**O'Connell Street Public School
SSD 7372 MOD 5 – Revised Design
Statement of Heritage Impact - Addendum**

I am writing in support of the shade structure proposed at O'Connell Street Public School, adjacent to Building B within the north-west corner of the site. The works are within the State Heritage Register curtilage of the Marsden Rehabilitation Centre Group (Former King's School) SHR 00826. This letter should be read in conjunction with the Statement of Heritage Impact which accompanied the original proposal.

DRAWING TITLE
STRUCTURAL DRAWING
FRAMING PLAN

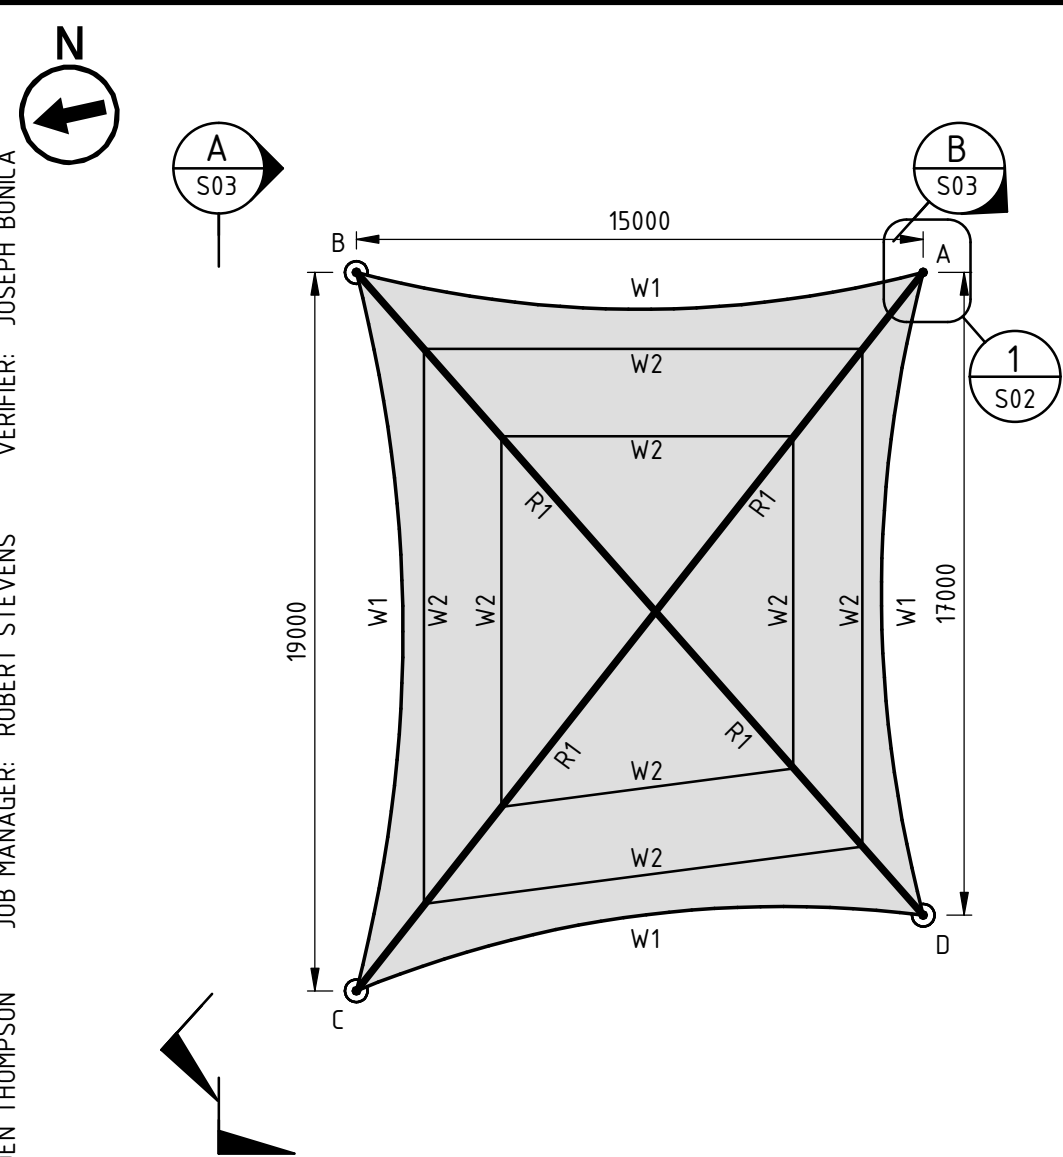
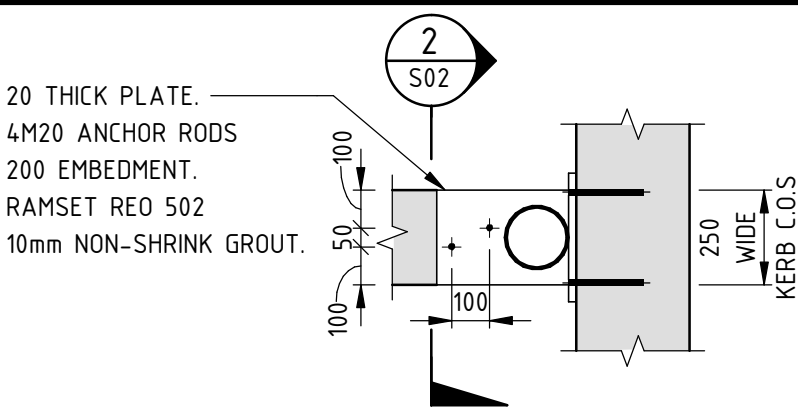
The shade sails would largely not intrude into significant views to, and across, the site, but the extension of the structure beyond the northern building line of the former dormitory would increase the visibility of the structure from O'Connell Street and is not supported. Existing vegetation along O'Connell Street may provide some screening, but to further mitigate adverse impacts, the shade structures should not extend beyond the northern building line of Building D;

The size of the shade structures is to be reduced so that they do not extend further north than Building D.

The height of the main shade sail appears excessive, rising above the first-floor openings, with a curved roof that is unsympathetic to the formality and horizontal lines of Building D. Whilst it is acknowledged that the structure is relatively simple and modern - which is positive - the negative impacts to the character and setting of the building could be mitigated by reducing the height of the main sail to sit below the first floor openings, and corresponding more closely to the height of the triangular sail. A flatter sail may help reduce the height whilst still accommodating the topography;

The large shade sail is to be reduced in height to sit below the first-floor openings.

Consideration should be given to a flatter sail design which corresponds more closely to the height of the triangular sail.

The size of the shade structures is to be reduced so that they do not extend further north than Building D.

In response to OEH's comments, the design has been revised so that the structure does not extend beyond the northern boundary of Building D, further mitigating any potential heritage impacts. Further the number of sails has been reduced from two to one as illustrated by the site plans shown overleaf.

The design has been revised to reduce the height of the shade sail structure by 700mm at the ridge, however, it is not possible to reduce the height of the ridge to sit below the first floor windows as requested by OEH. This is due to the minimum height of 2100mm at the eastern side and the topography of the site as illustrated below.

The large sail structure has been reduced in height by 700mm at the ridge, however cannot sit below the first floor openings due to the 2100mm minimum height restriction at the edges and structural design criteria. The revised design is substantially lower than the original proposal and is considered acceptable from a heritage perspective.

The triangular sail has been removed from the proposal. A flatter sail design was considered in developing the revised proposal, however proved impractical. This is because the density of the fabric required to provide high UV protection must be installed to falls to ensure that any water is able to quickly run off, especially in heavy rain. If the sail was flatter the fabric would stretch and sag from the weight of water and not drain correctly. The fabric cannot be installed flat.

The shade structures have been reduced to a single structure and do not extend further north than Building D. This condition is acceptable.
